MMC Congress Street building site plan review

Wed, Oct 31, 2018 at 12:55 PM

Hi Nell. Here are my review comments:

SHEET NUMBER  
**C11-01**

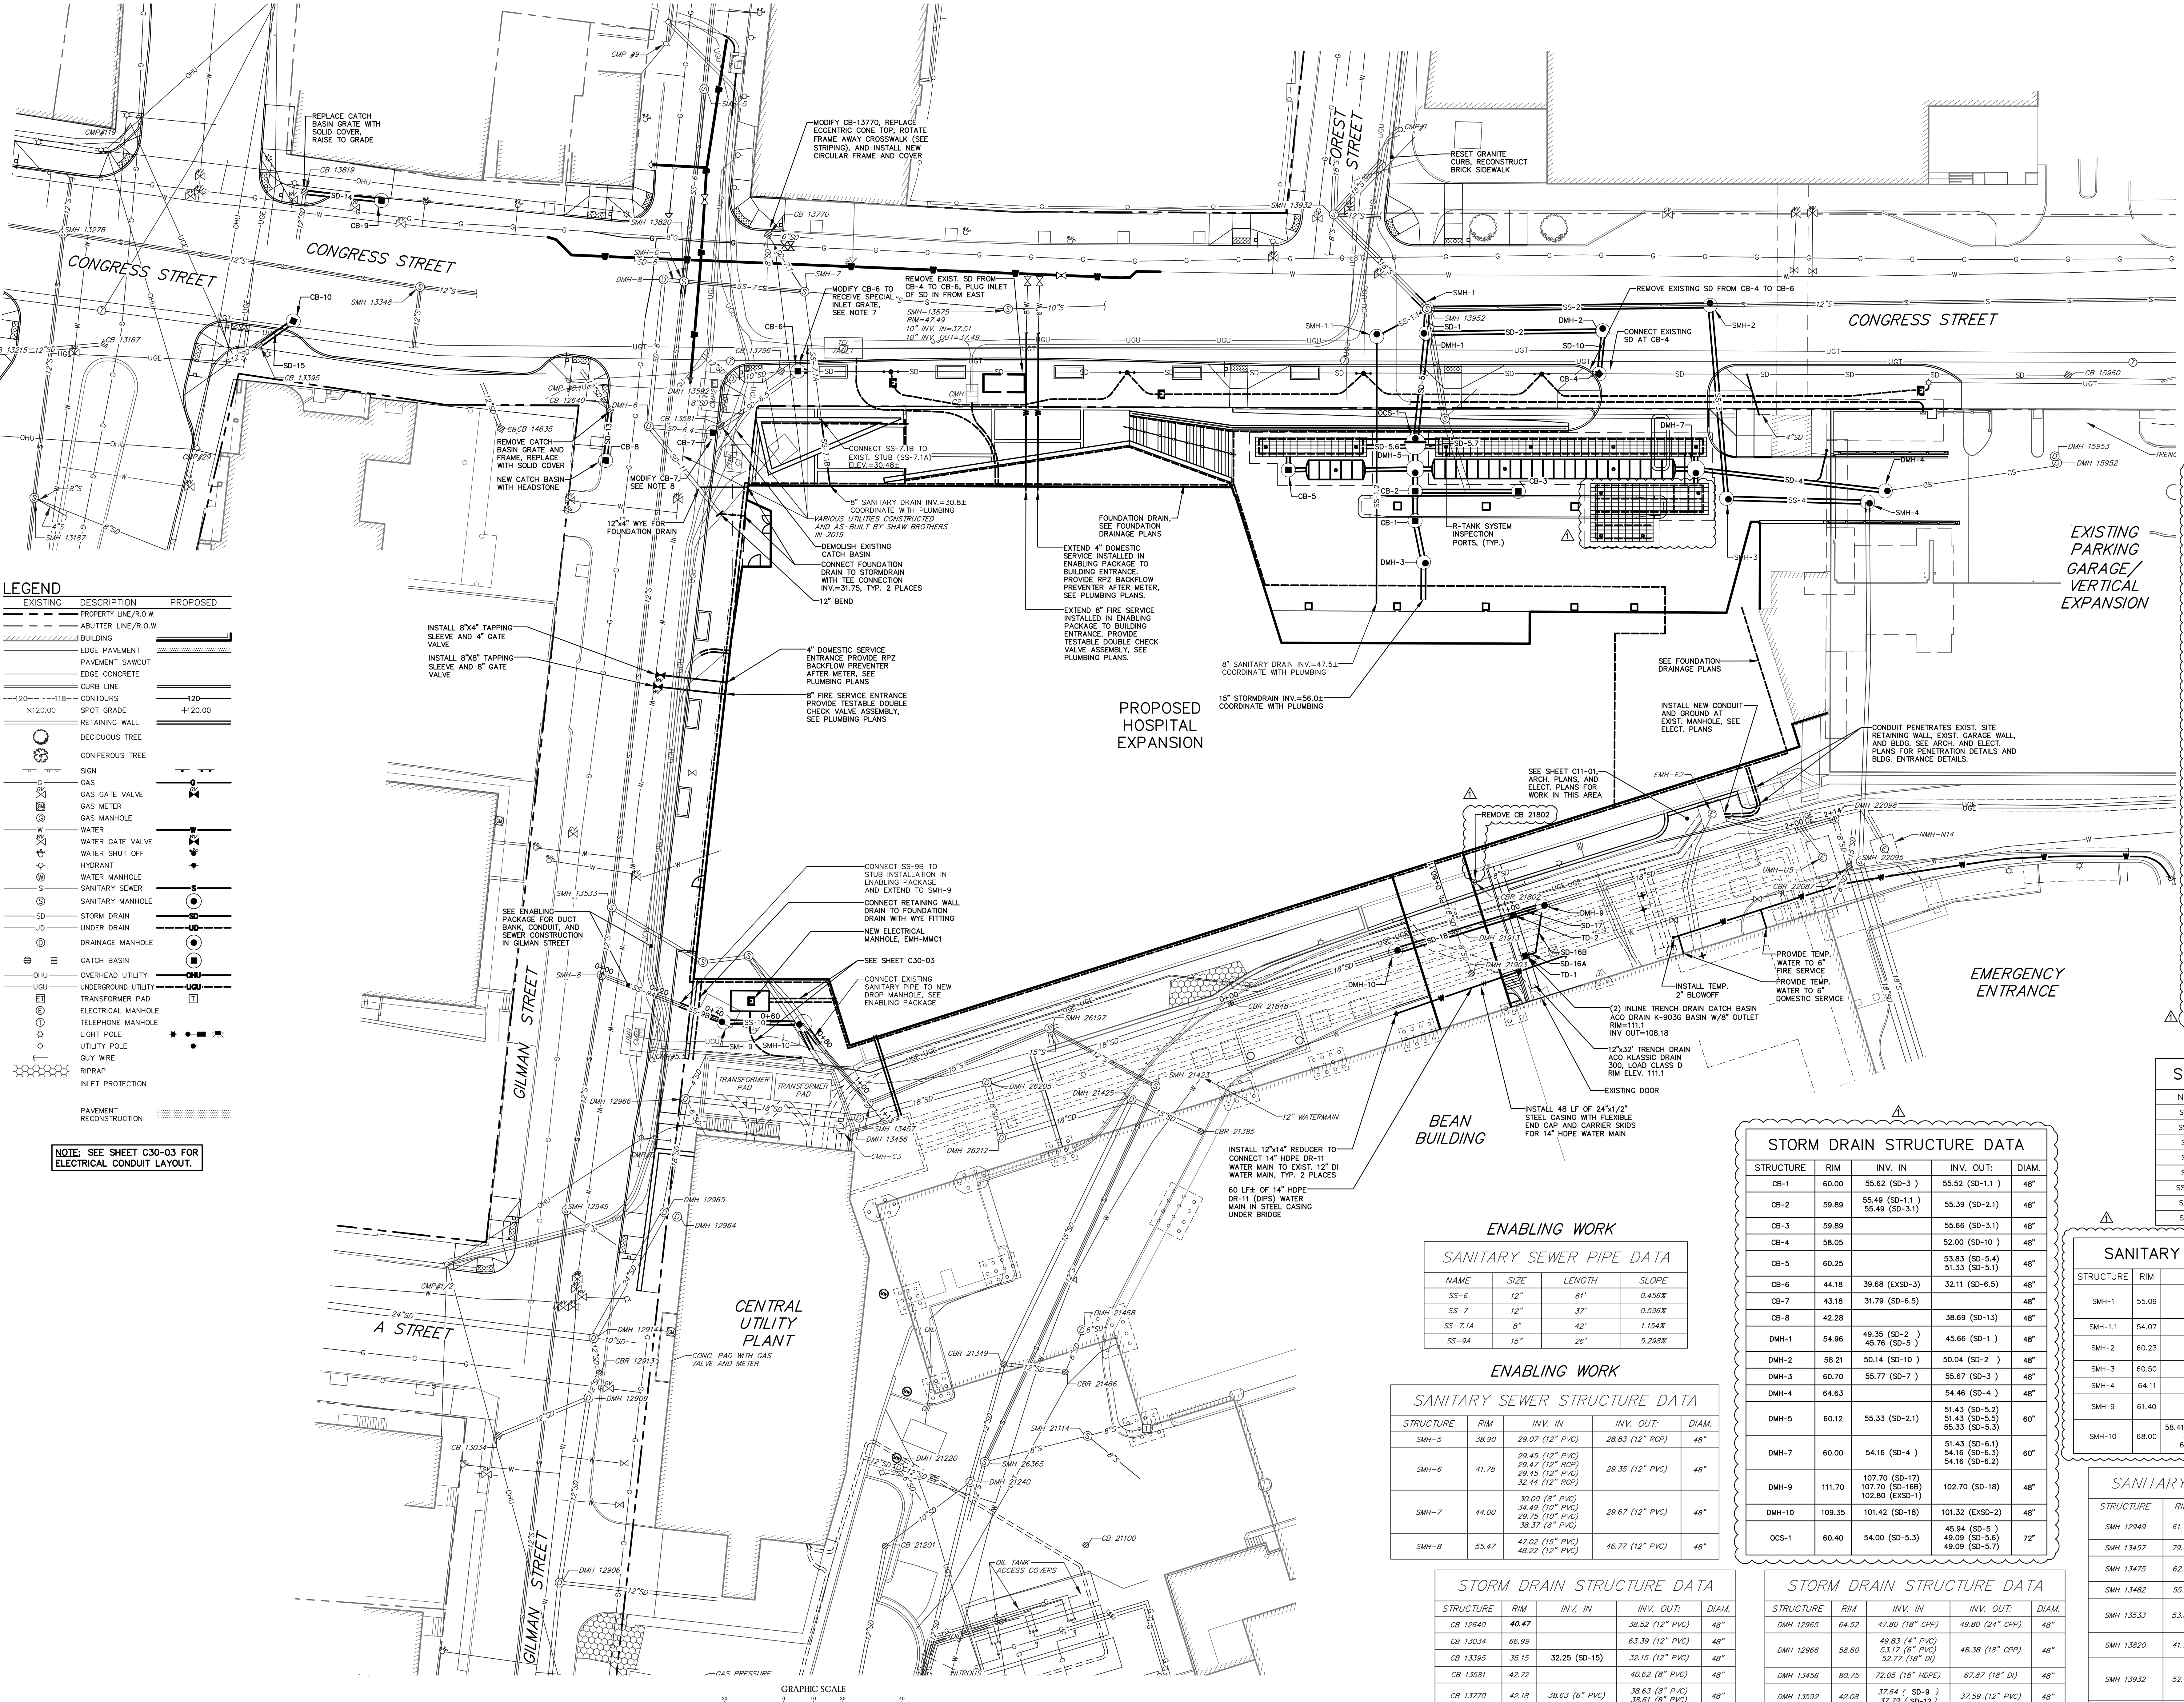
1. A note should be added to Sheet 2 of the EC plan that defines the elevation datum for this project. It was listed as NAVD88 on the 2009 version of these plans.
2. A note should also be added to Sheet 2 of the EC plan and to both of the Utility Plan sheets that warns people that this elevation datum (NAVD88) is not the same as "City Datum" (NGVD29). A conversion formula should also be noted.
3. A note should be added to the EC plan that refers the reader to the Utility Plan sheets for sewer and drain pipe invert elevations, sizes and materials.
4. State Plane coordinate pairs should be labeled for at least two of the property corners on the EC plan.
